**MECKLENBURG COUNTY**  
**Land Use & Environmental Services Agency**

**MEMORANDUM**

Subject: Initial Rezoning Petition Comments

**2020-137: Nest Homes**

DATE: 08/11/20	MPIC: WILL
DRAWN BY: DSB	CHECKED BY: WILL
PROJECT NUMBER: 00777.00	
SCALE: 1" = 60'	
TITLE: CONCEPTUAL SITE PLAN

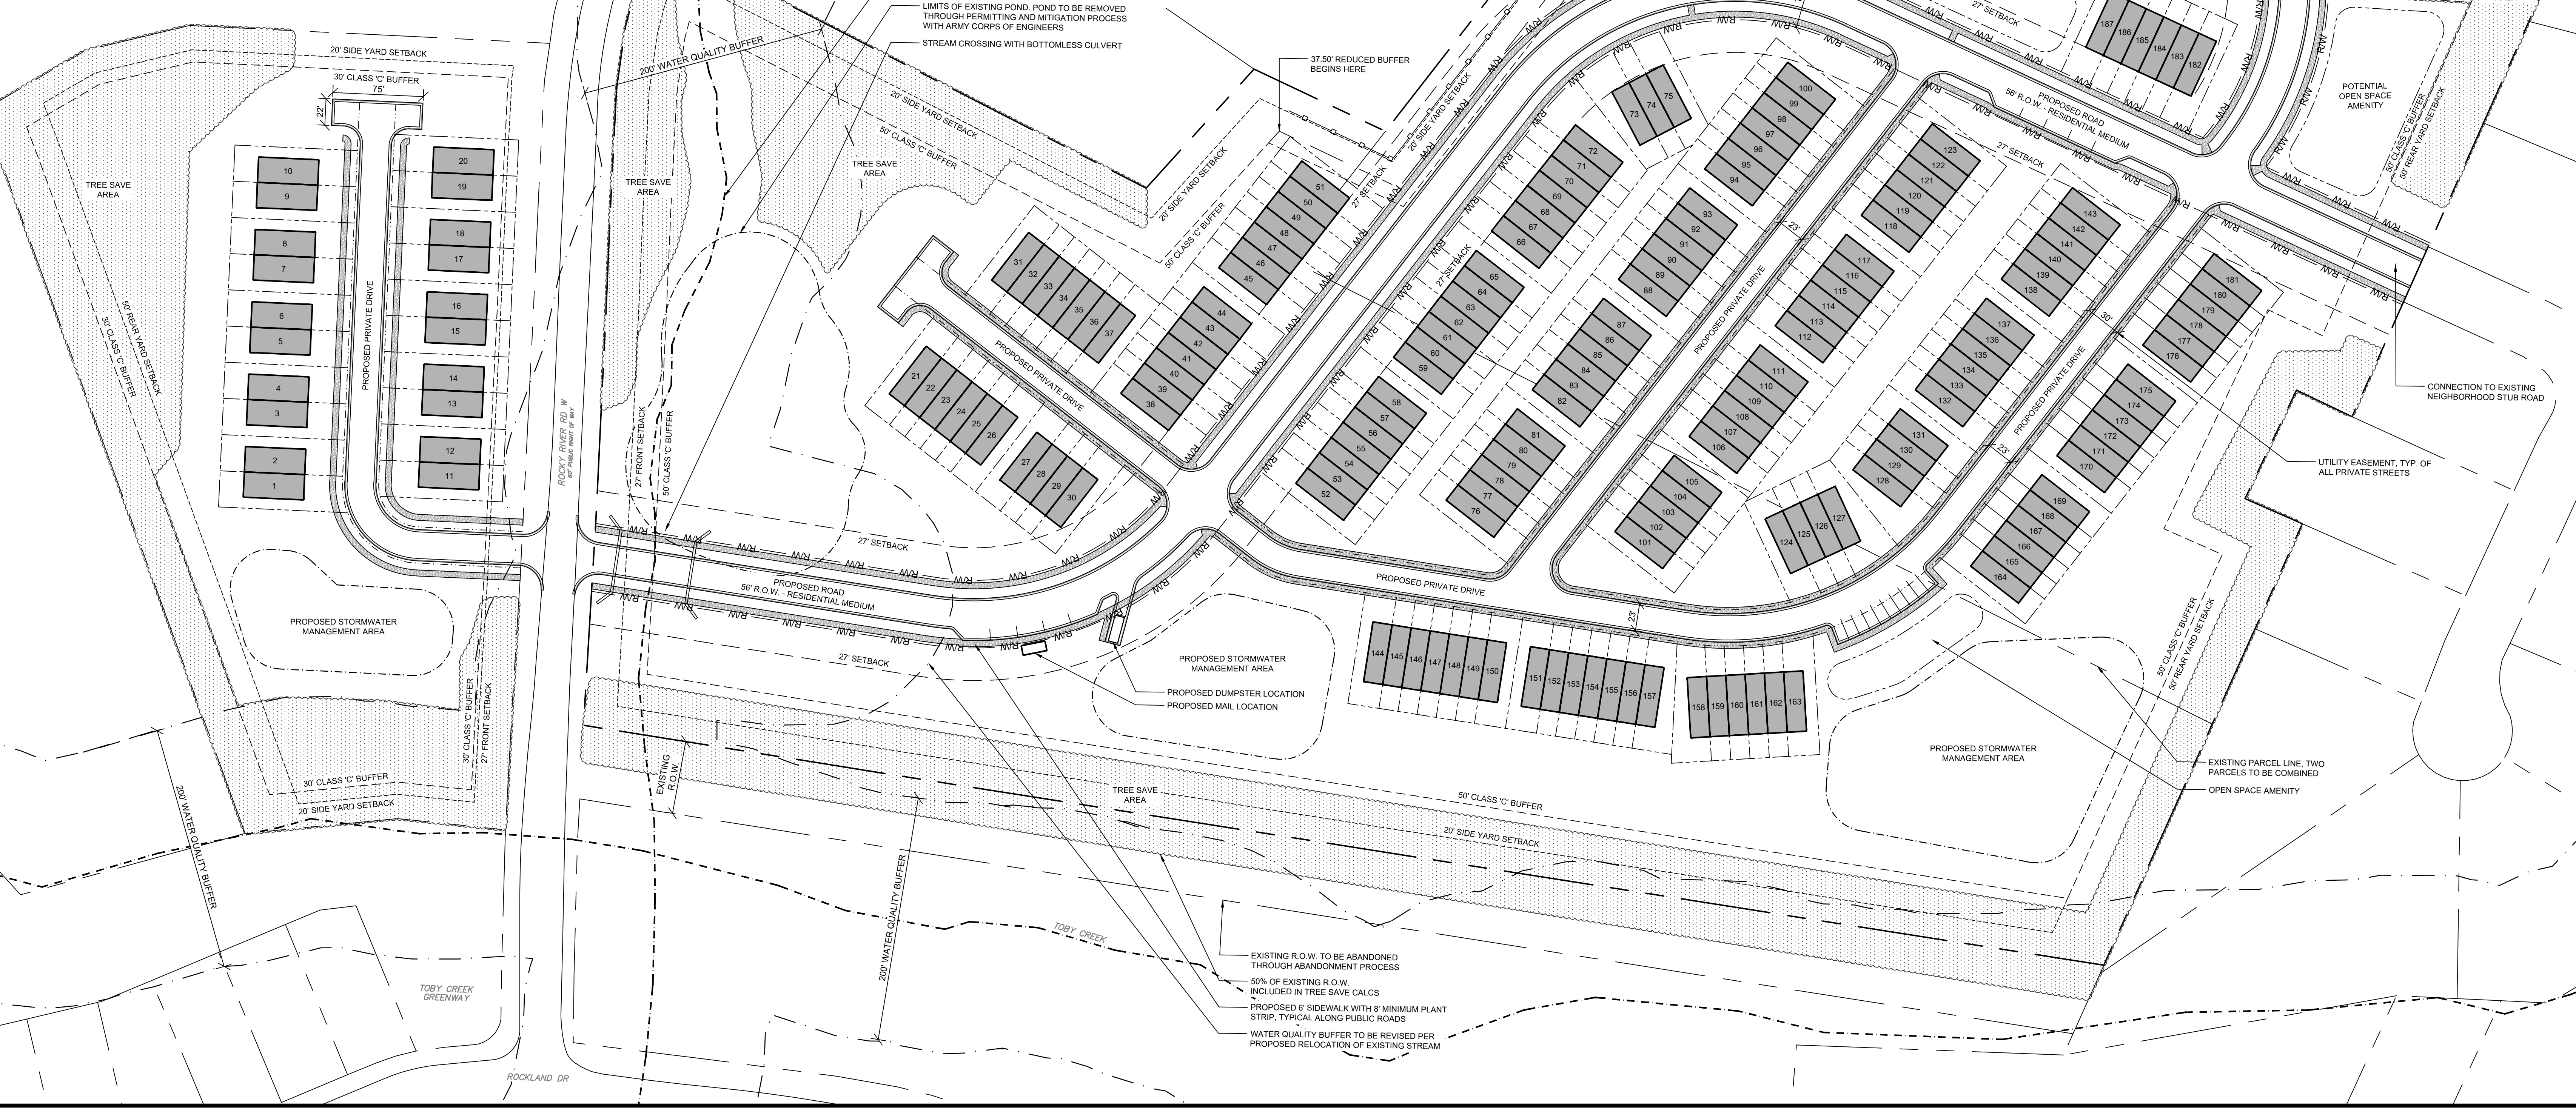
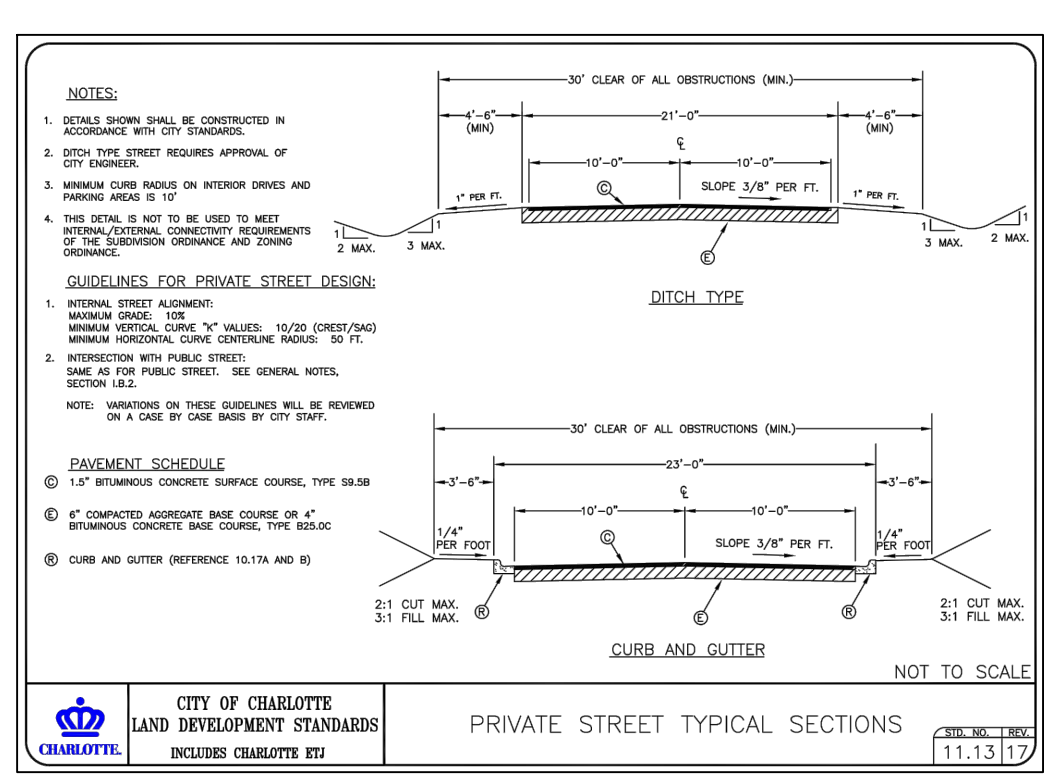
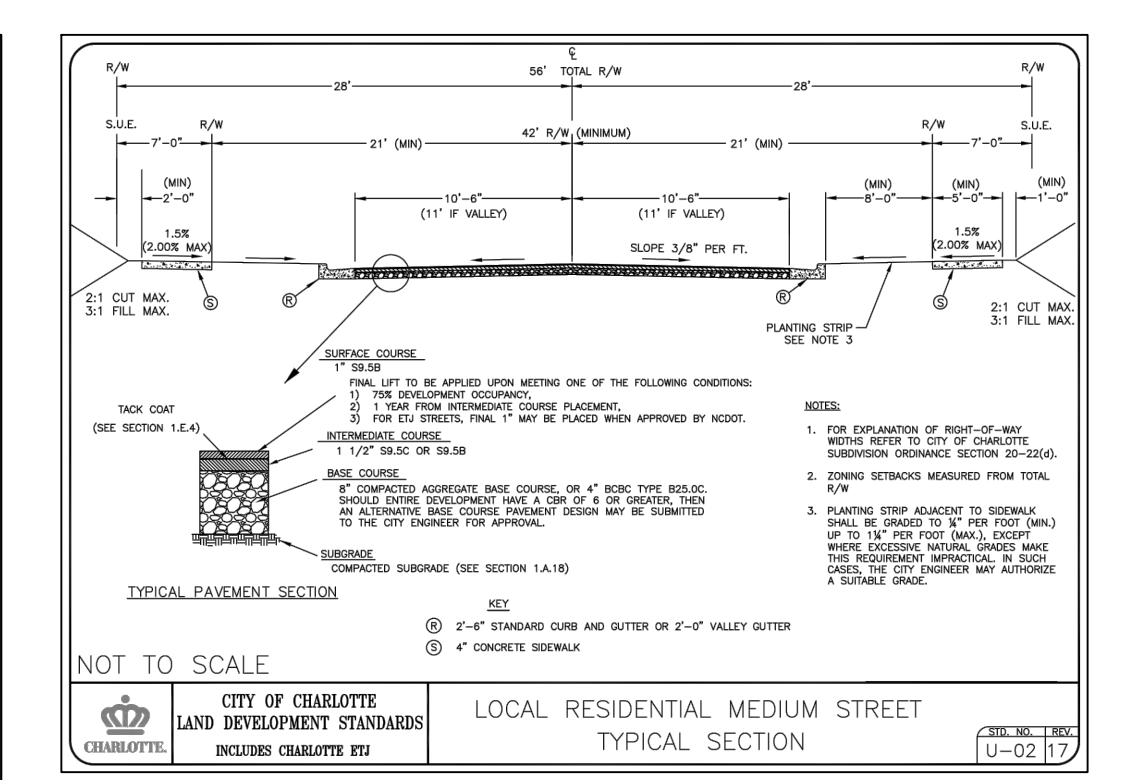
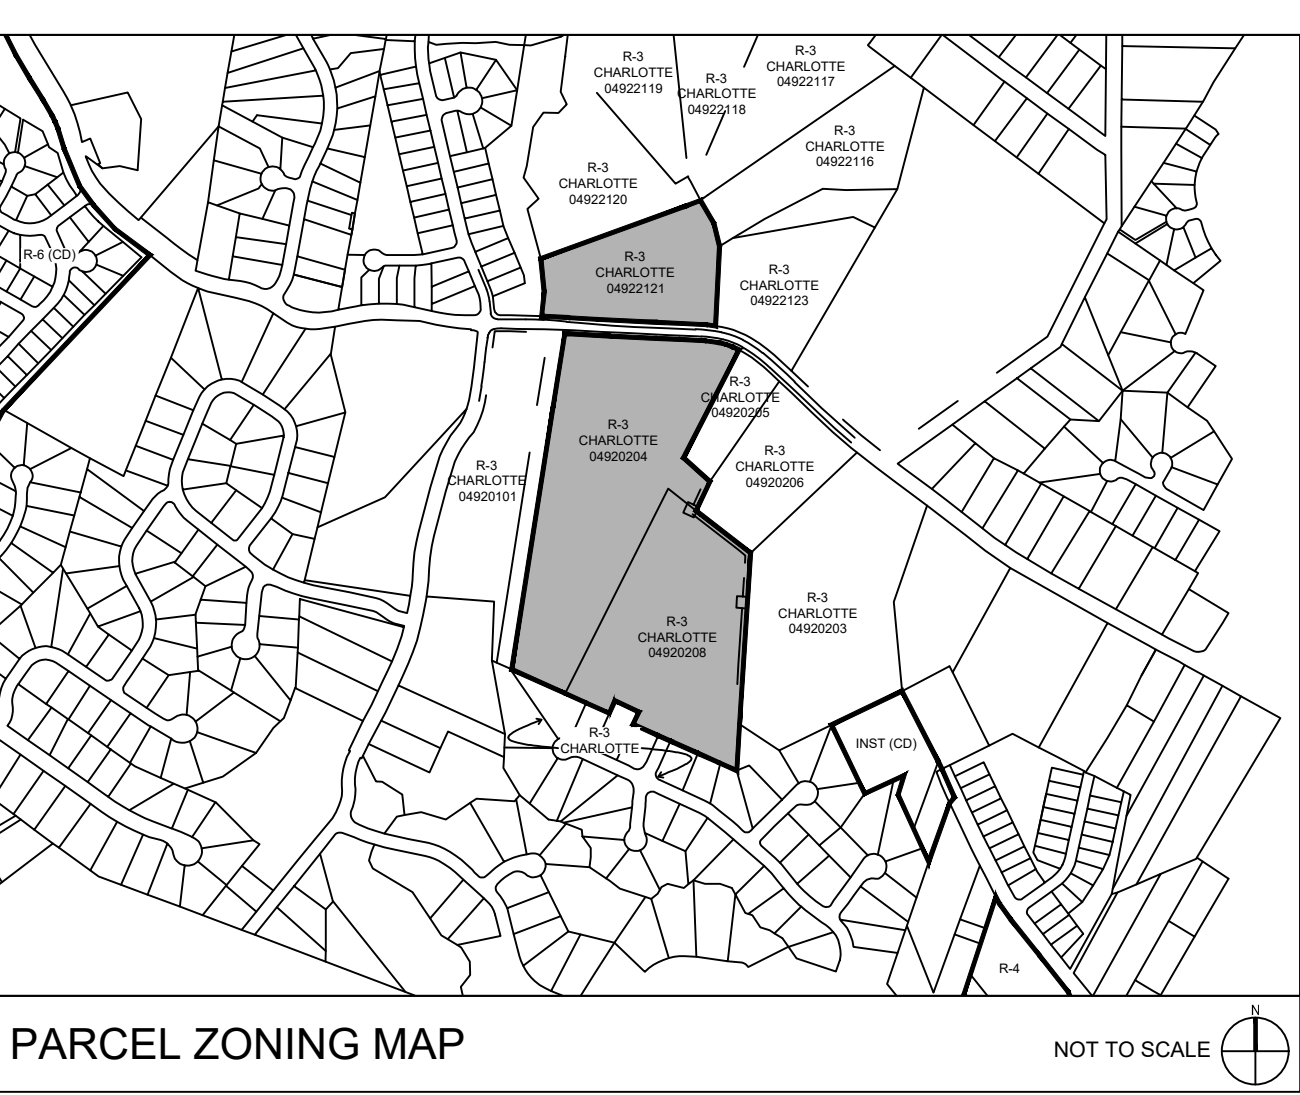
*Ground Water Services Comments:* Groundwater & Wastewater Services records indicate that a water supply well is located within the bounds of parcel 049-202-04. The water supply well should be protected during site development by flagging and fencing or be permanently abandoned in accordance with the Mecklenburg County Groundwater Well Regulations prior to site development commencing.

*Storm Water Services Comments:* A Floodplain Development permit must be obtained documenting compliance with the City of Charlotte Floodplain Regulations for all development occurring in the floodplain. In addition, staff recommend any structures proposed within the Community Special Flood Hazard Area be constructed to a Flood Protection Elevation equal to the Community Base Flood

Elevation plus two (2) feet of freeboard based upon recent analyses of the future floodplains supported by the Storm Water Advisory Committee.
